# PART B

**Assessment of project changes and response to submissions**

## 4 Environmental Assessment – general submission issues

Metres

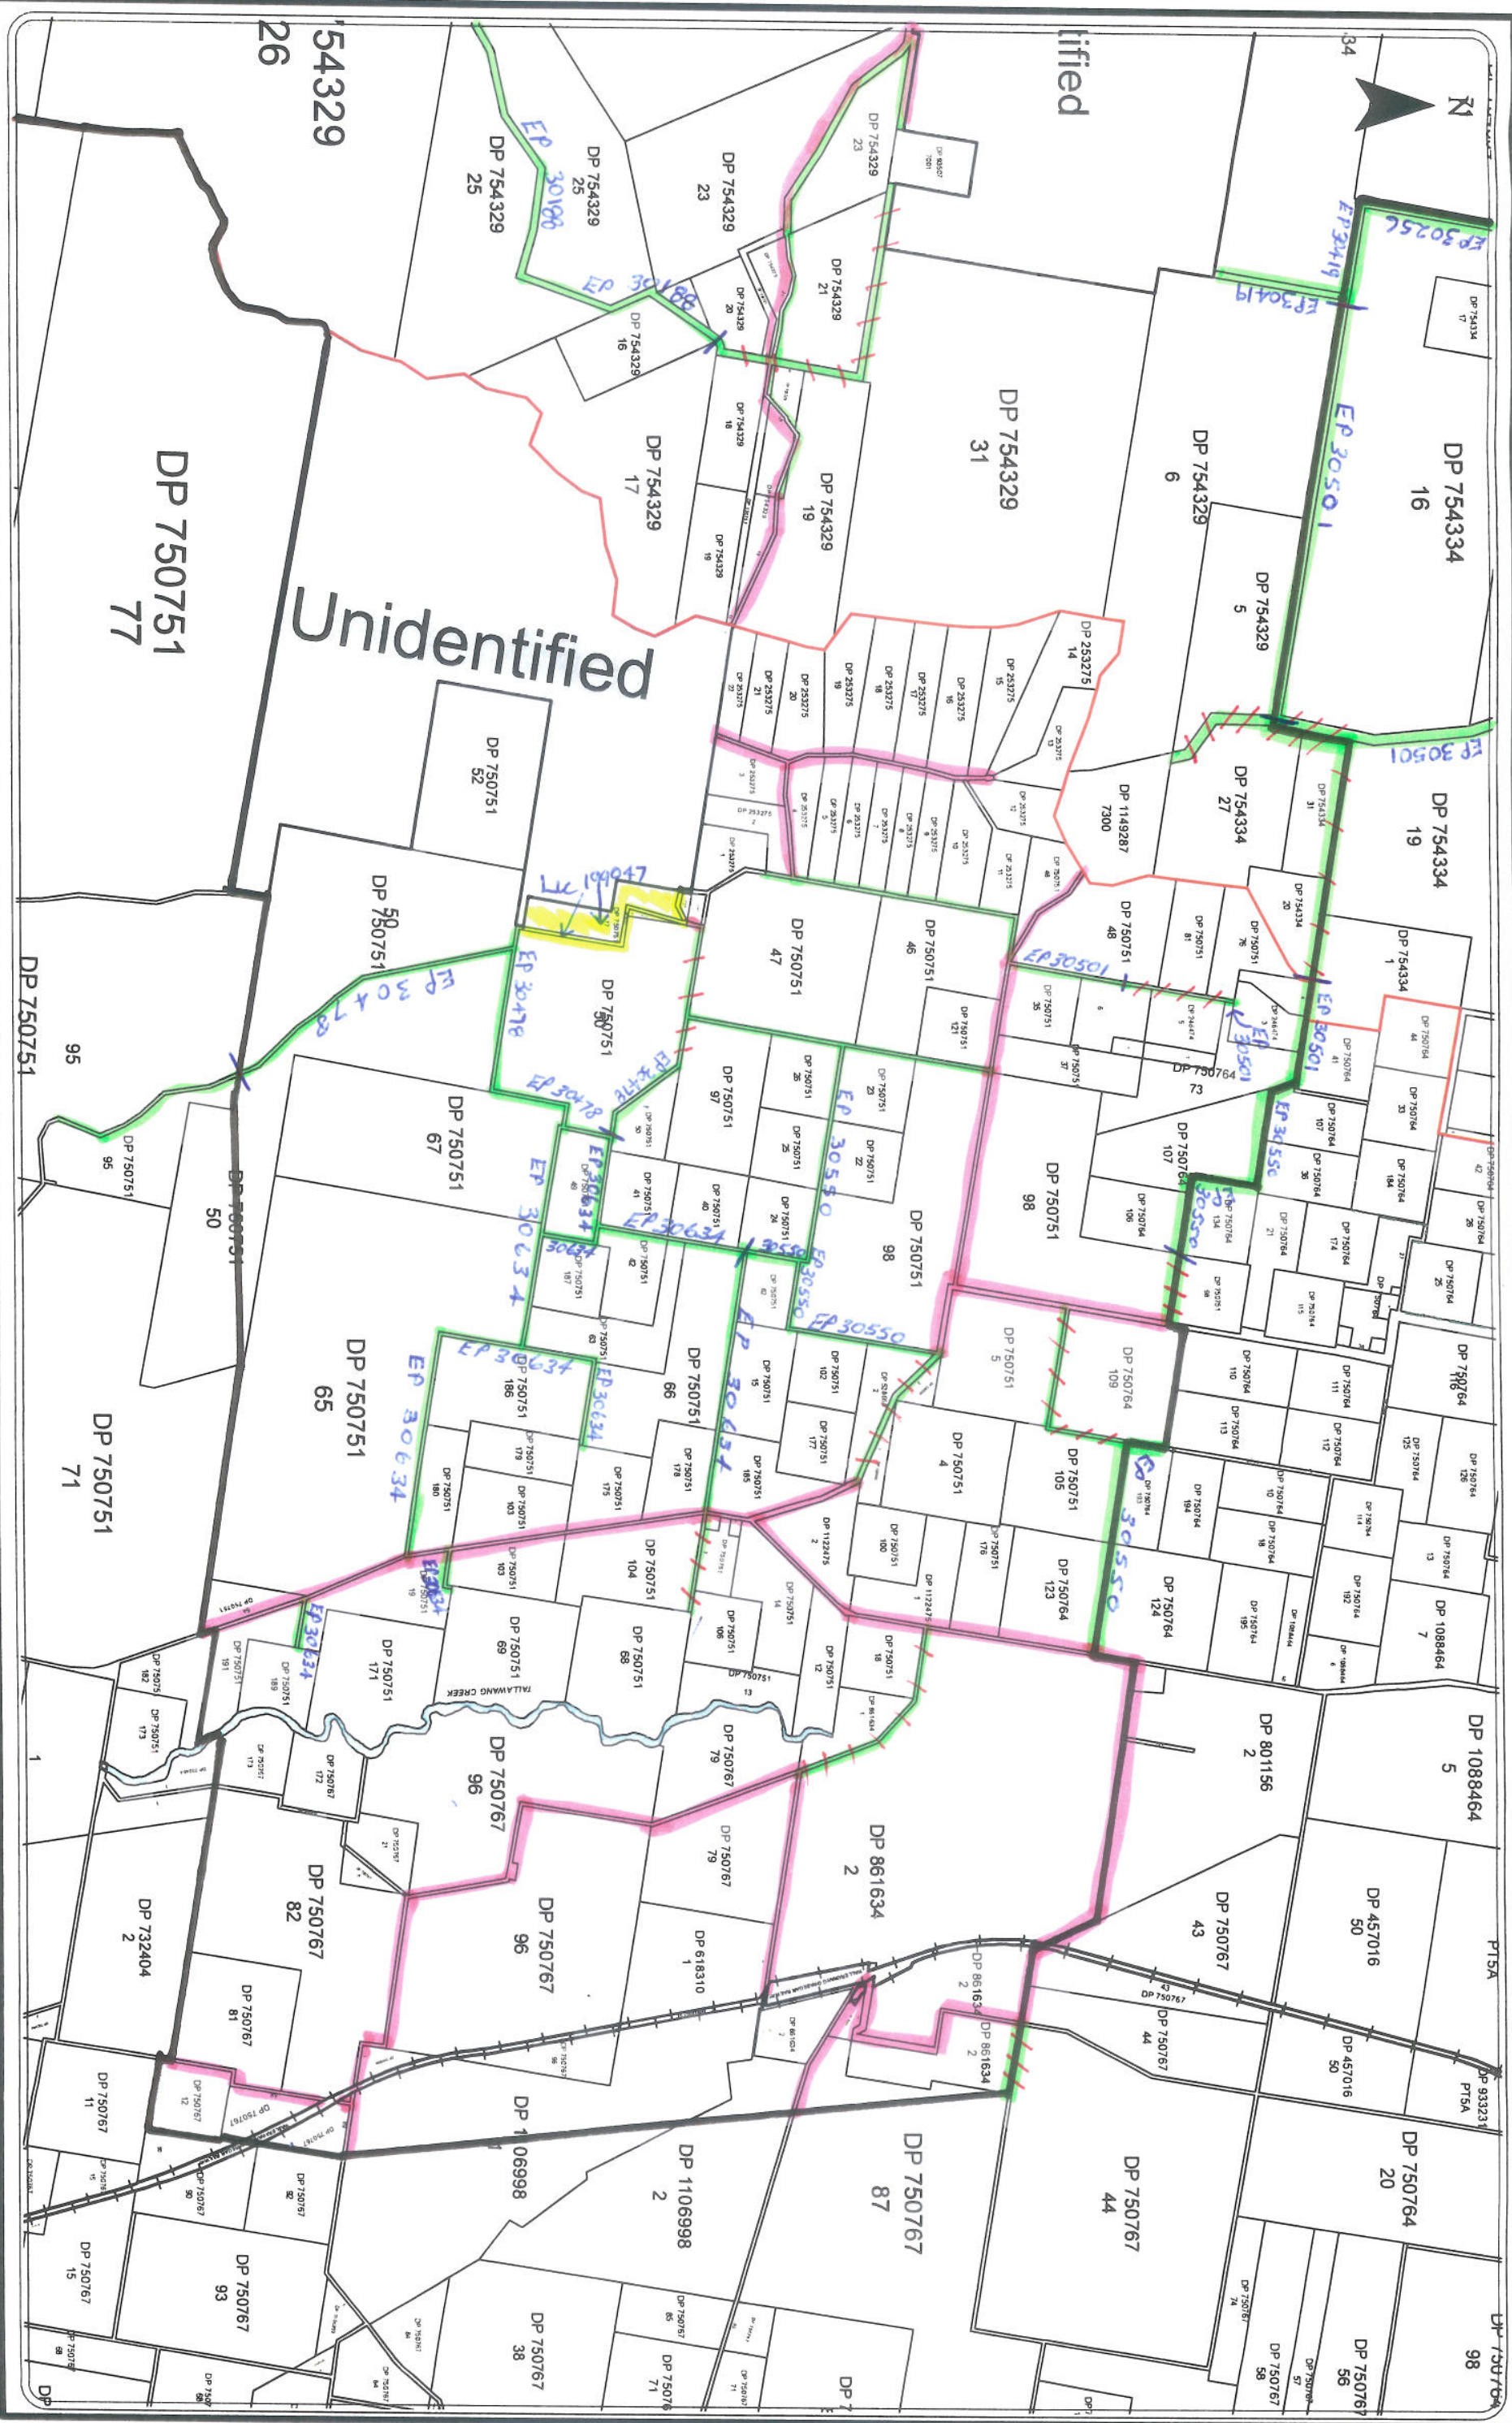
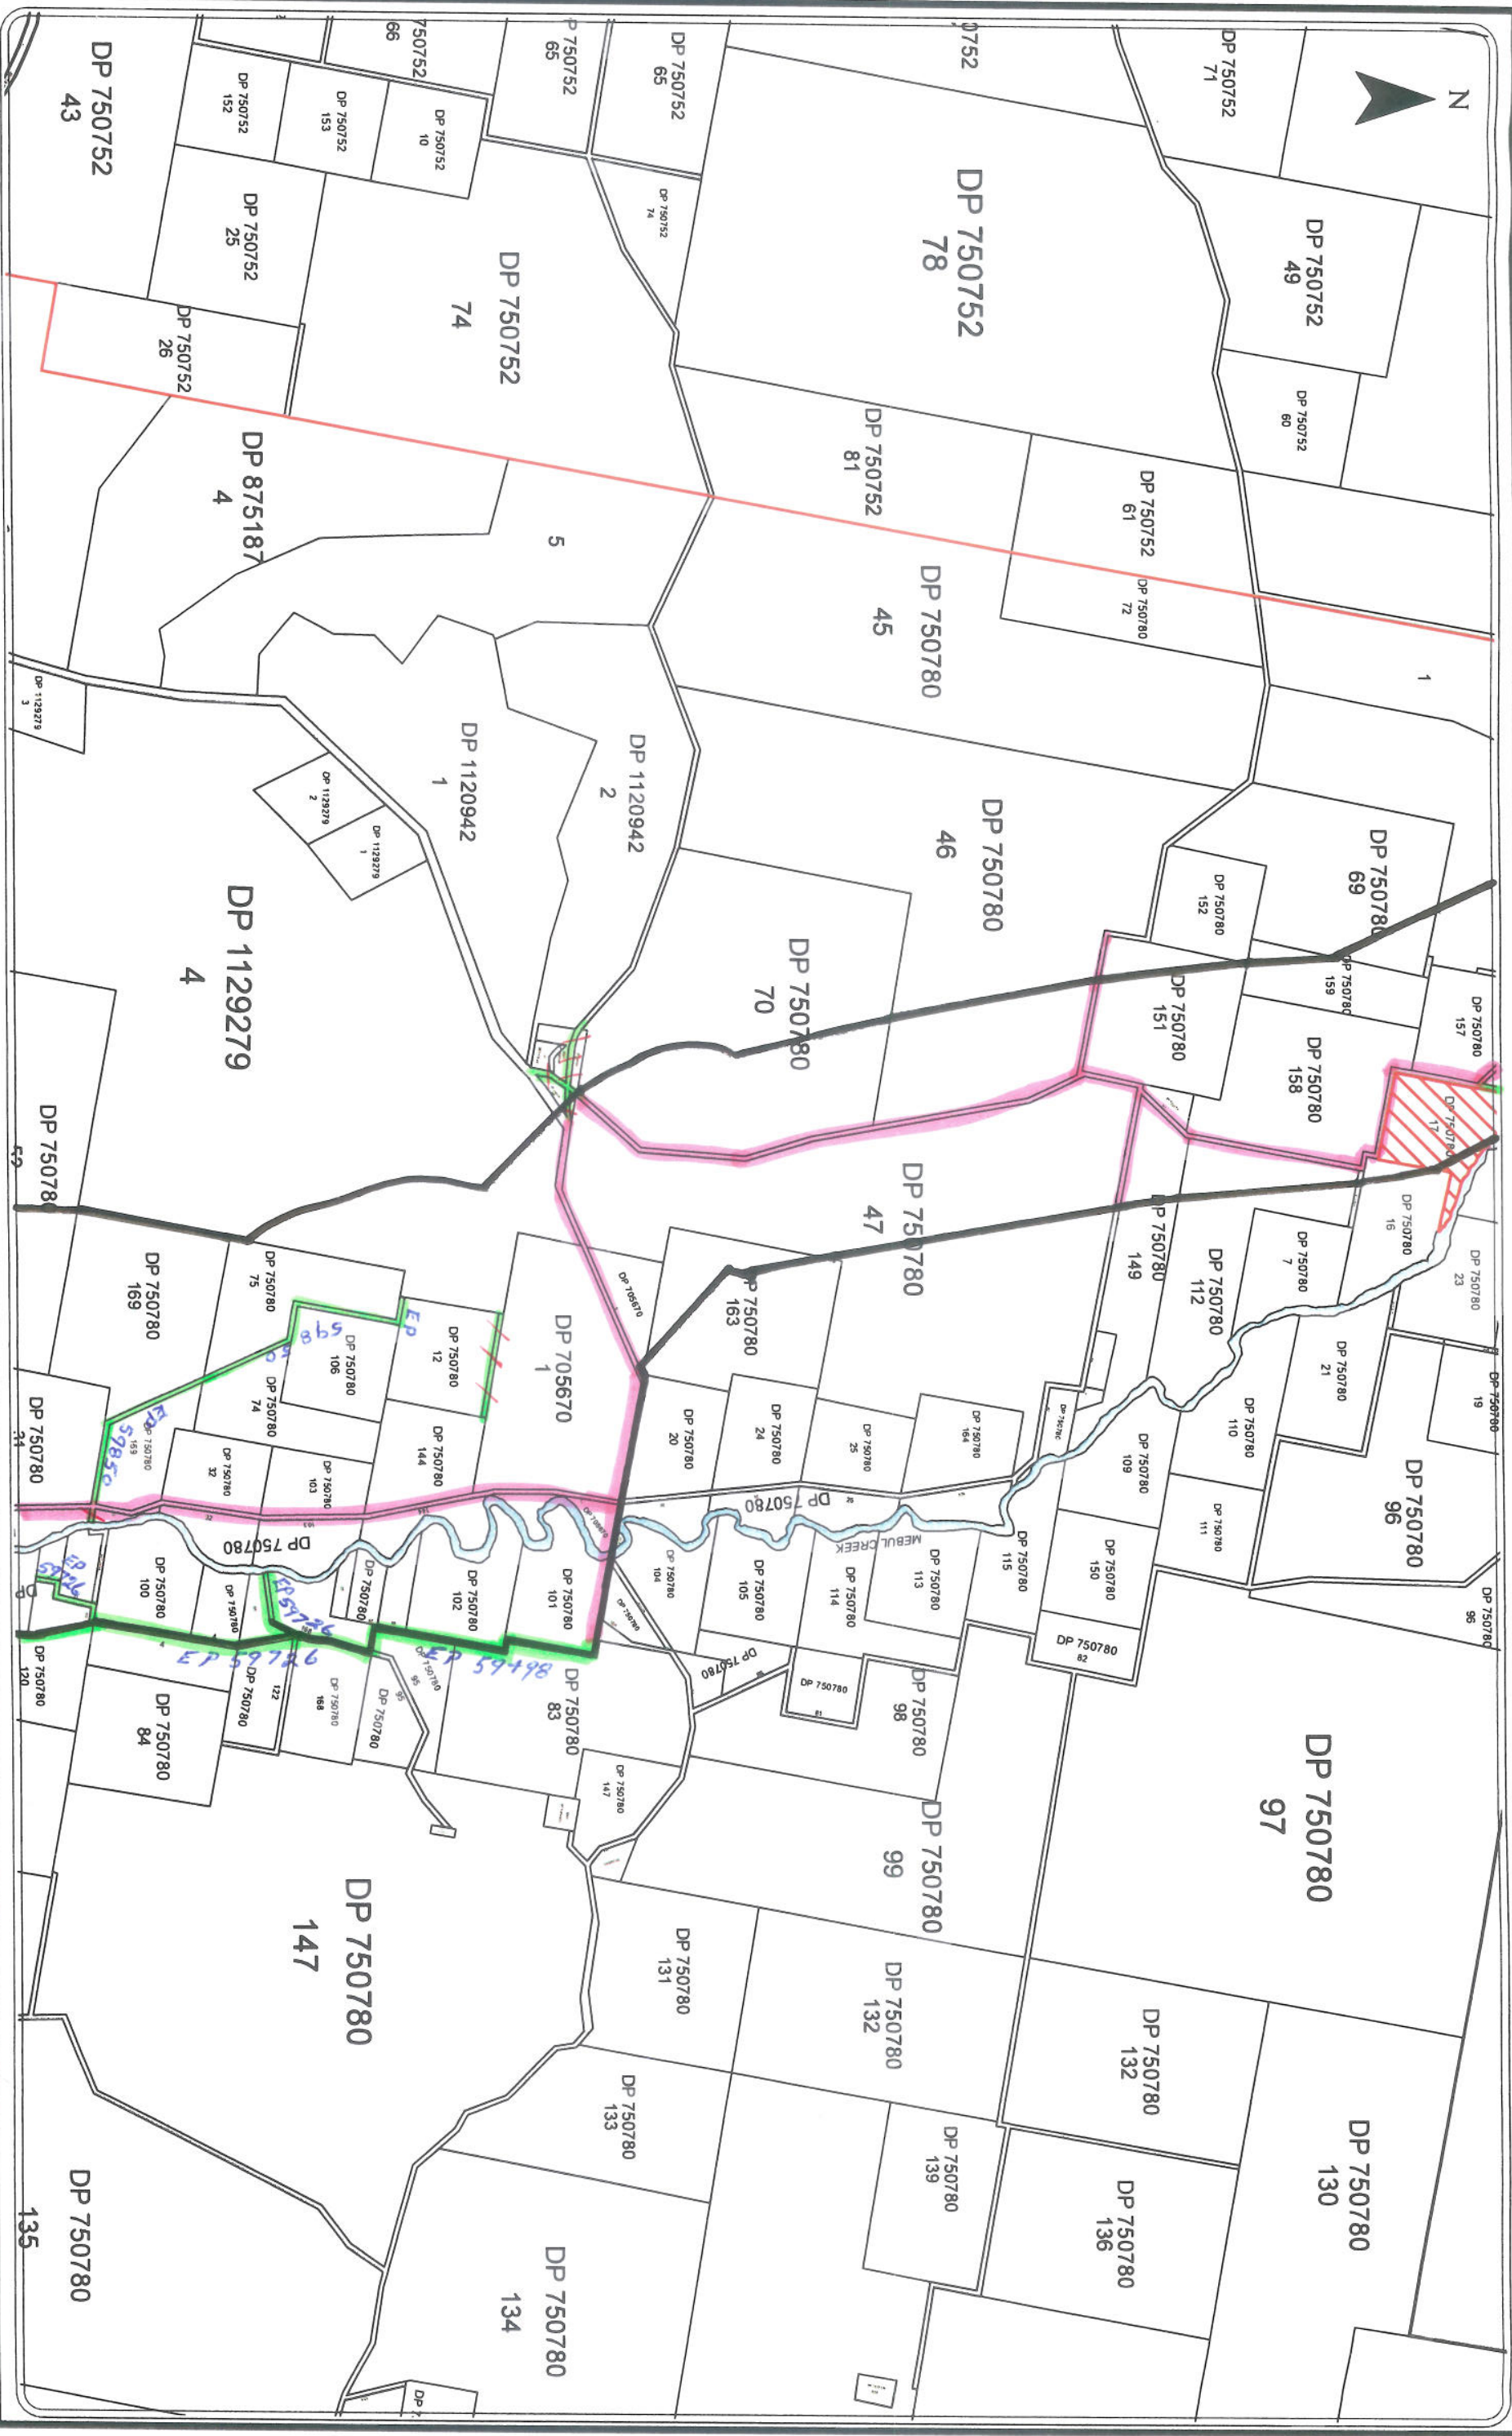
Crown Lands (part of the DPI) comments there are a number of Crown (and council) roads located within the mining area and the proponent will need to make applications to close and purchase these roads before any mining works begin. Contact should be made with the Catchments and Lands Division (Crown Lands) for further details and to determine appropriate actions. Crown Lands goes on to comment that there are a number of areas of Crown land as well as a large number of Crown (and council) roads within the Project Application Area (but located outside the mining area). The proponent will need to contact the Catchments & Lands Division (Crown Lands) to obtain the necessary approvals to occupy Crown land and/or to determine appropriate actions to allow any Crown roads to be used for ingress and egress from the mining area.

CHC will apply to buy and close the required Crown and council roads and for ongoing access to Crown land. An updated map of Crown land is provided in Appendix D. CHC does not object to the conditions proposed by Crown Lands but notes that draft project approval conditions are prepared by the DP&I and final project approval conditions are prepared by the PAC where the commission is the determining authority as will be the case for the Project.
